Town & Country Planning Act 1990 (as amended)
Town & Country Planning (Development Management Procedure) (England) Order 2015

Application for Planning Permission for Works or Extension to a Dwelling

Development: Single storey front & side extensions
Location: 3 Brigham Place Felpham West Sussex PO22 7NW

block plan
1 : 500

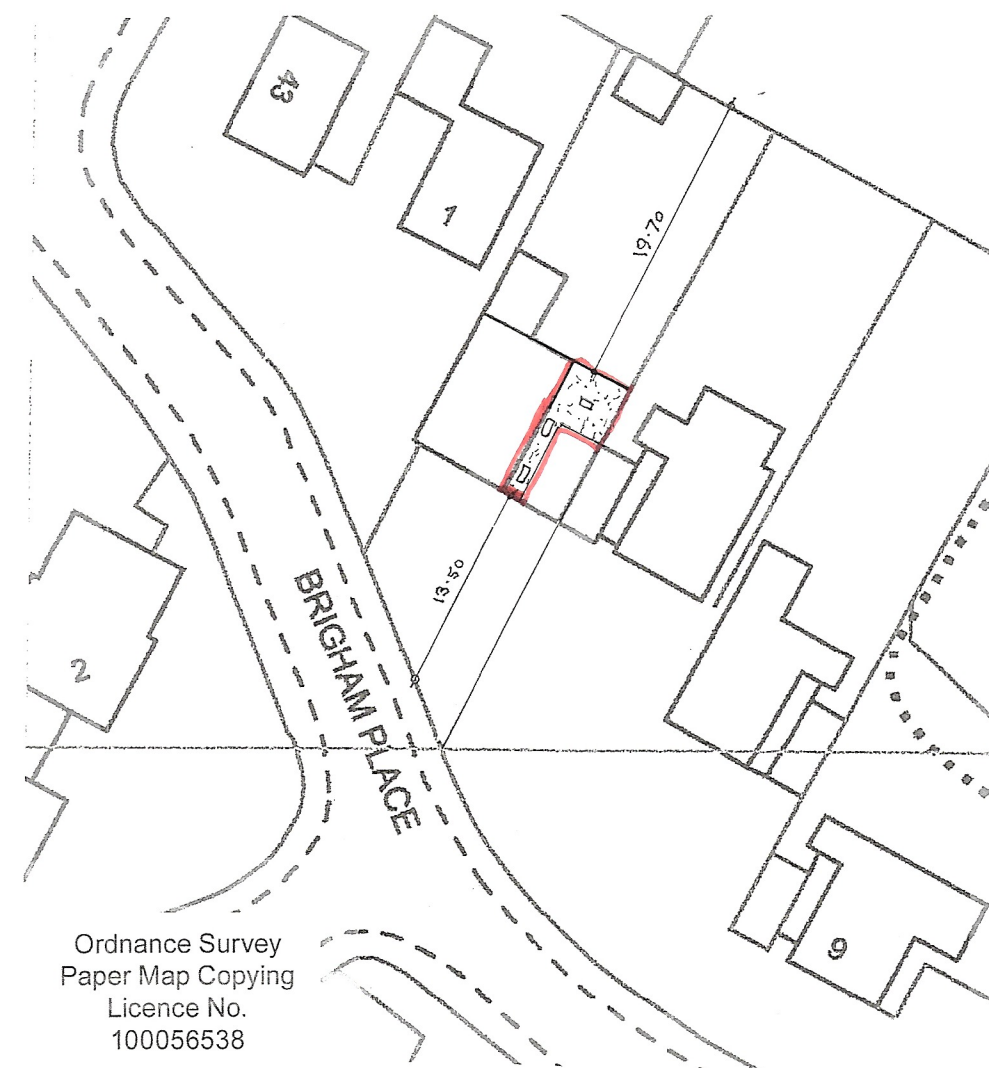
Please provide a North point on the location and block plan.
